Tuck O'Brien
City Planning Director, Planning Division

Project Name: 50 Cove Street – New Commercial/Industrial Building
Planner: Matthew Grooms
Project ID: 2017-116
Address: 50 Cove Street
Dear Mr. Bass: CBL: 010 H004001

TO: Matt Grooms, Planner
FROM: Lauren Swett, P.E. & Loren Joyce, E.I.T.
DATE: June 30, 2017
RE: 50 Cove Street, Level II Site Plan Application

RE: Staff Review Comments for 50 Cove Street (2017-116) – Planning Authority Review

DRAWING NAME: SITE DETAILS - 2
PROJECT NAME: 50 COVE STREET SITE REDEVELOPMENT
CLIENT: RANDOM ORBIT, LLC.
30 DANFORTH STREET, SUITE 213 PORTLAND, ME 04101

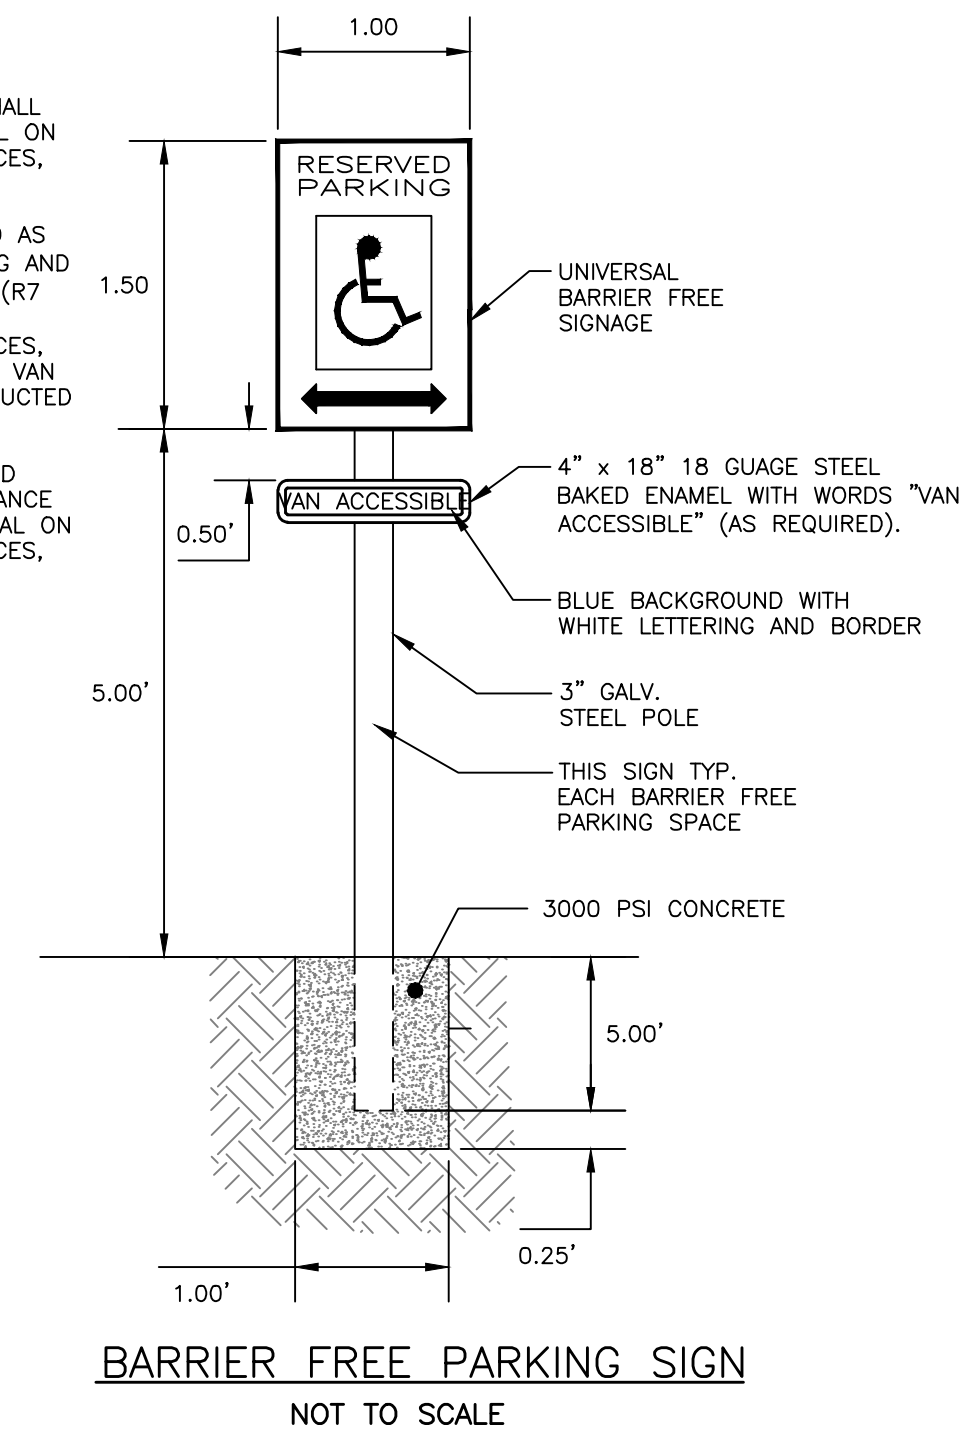
- 2) Per the current sidewalk material policy, driveway aprons must match the adjacent sidewalk materials.
- 3) The plans identify handicap accessible parking spaces, however, they do not appear to correspond to accessible doorways. Doorways should be shown on the site plan for reference.

DRAWING NAME: EROSION & SEDIMENTATION CONTROL DETAILS
PROJECT NAME: 50 COVE STREET SITE REDEVELOPMENT
CLIENT: RANDOM ORBIT, LLC.
 30 DANFORTH STREET, SUITE 213 PORTLAND, ME 04101

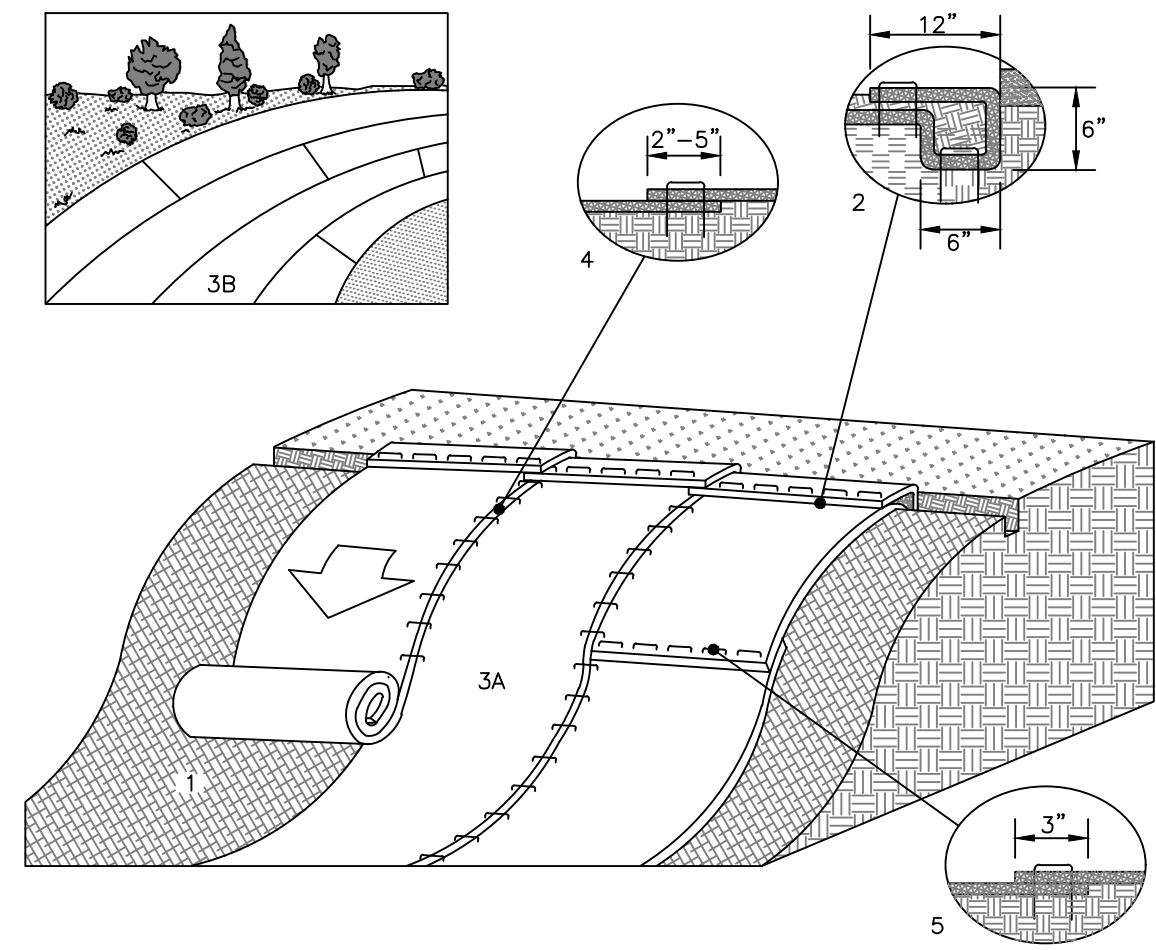
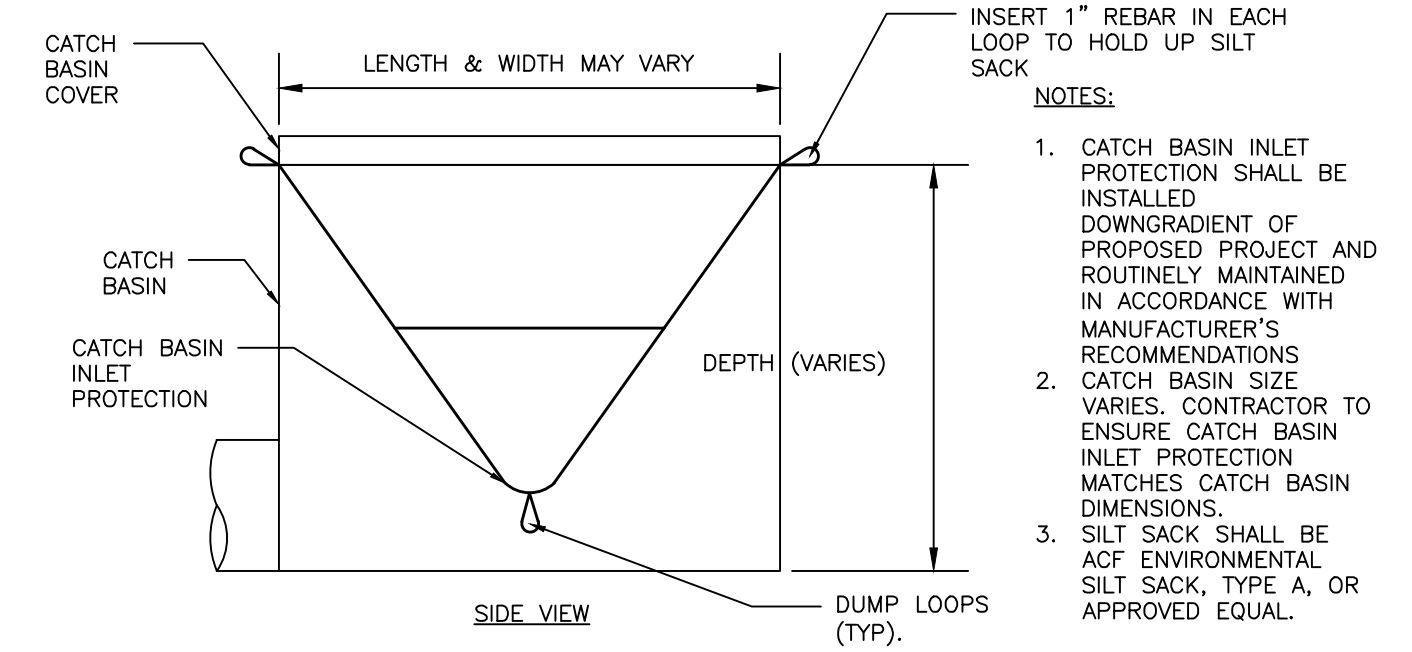
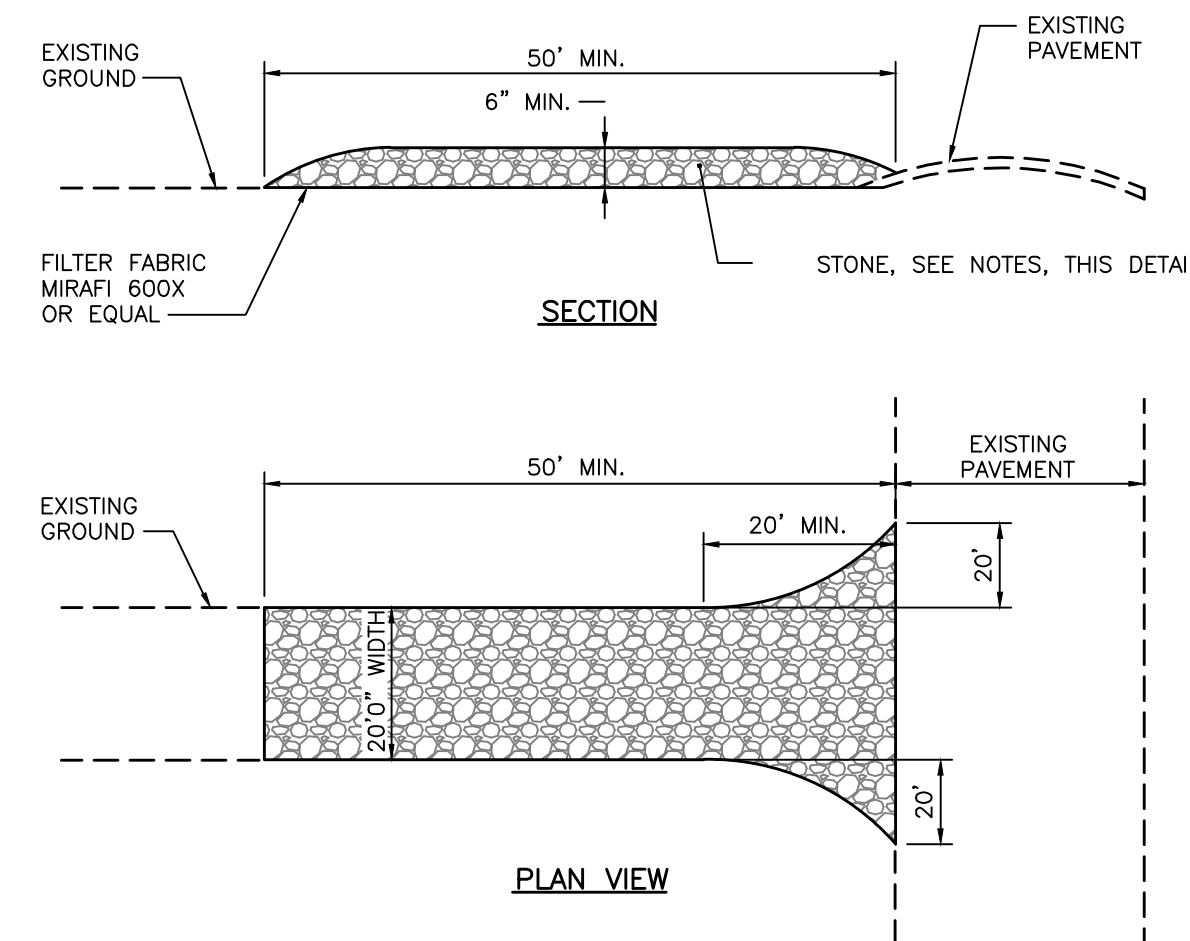
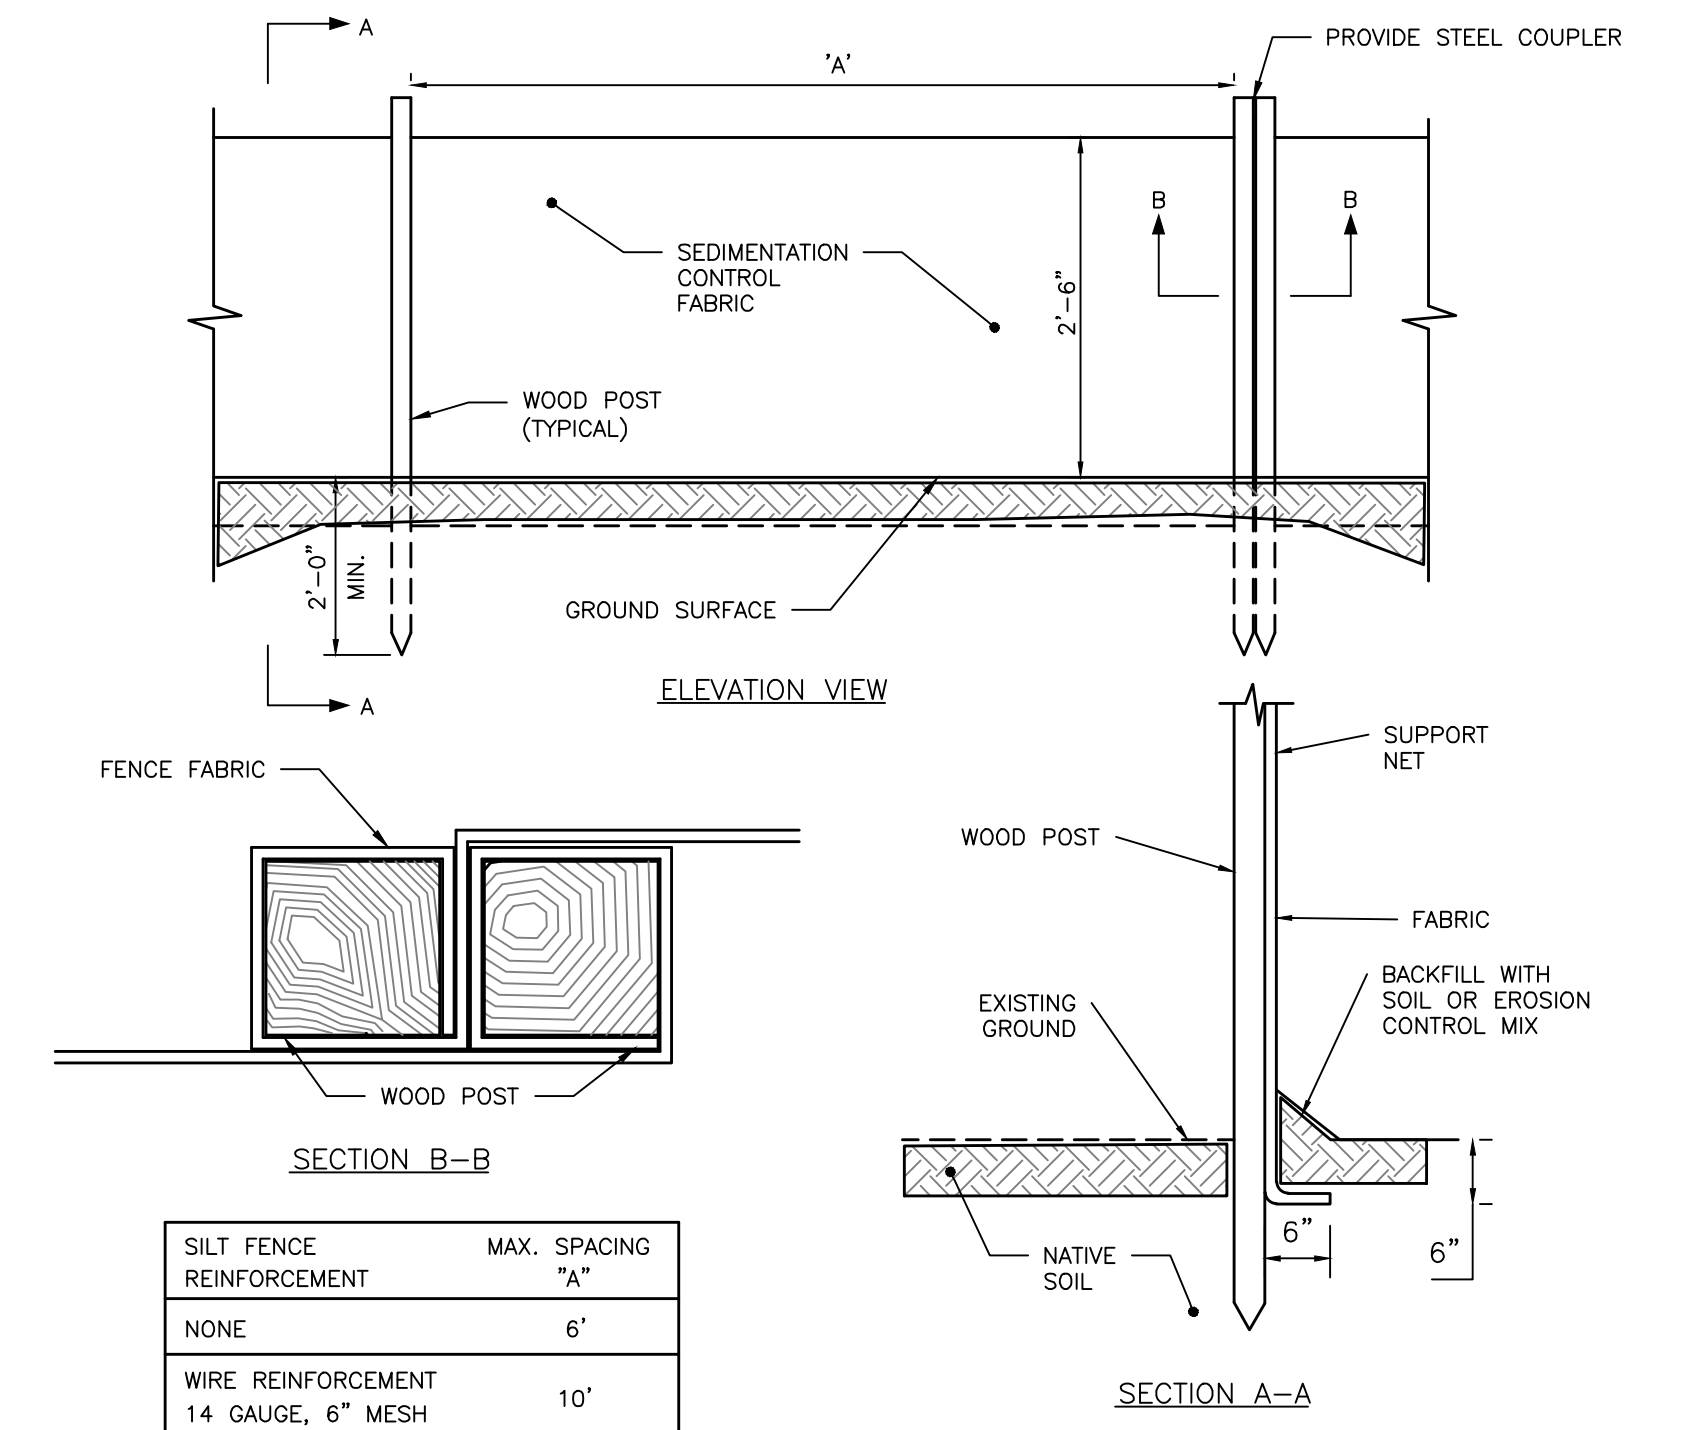
- a) Include sediment barriers downgradient of all proposed soil disturbances as required by the Basic Standards.
 - b) Basic Standards: Notes and details have been provided to address erosion and sediment control requirements, inspection and maintenance requirements, and good housekeeping practices in accordance with Appendix A, B, & C of MaineDEP Chapter 500. Notes have been provided on proposed locations; however, we recommend that locations of erosion and sediment control measures should be shown on the plans.
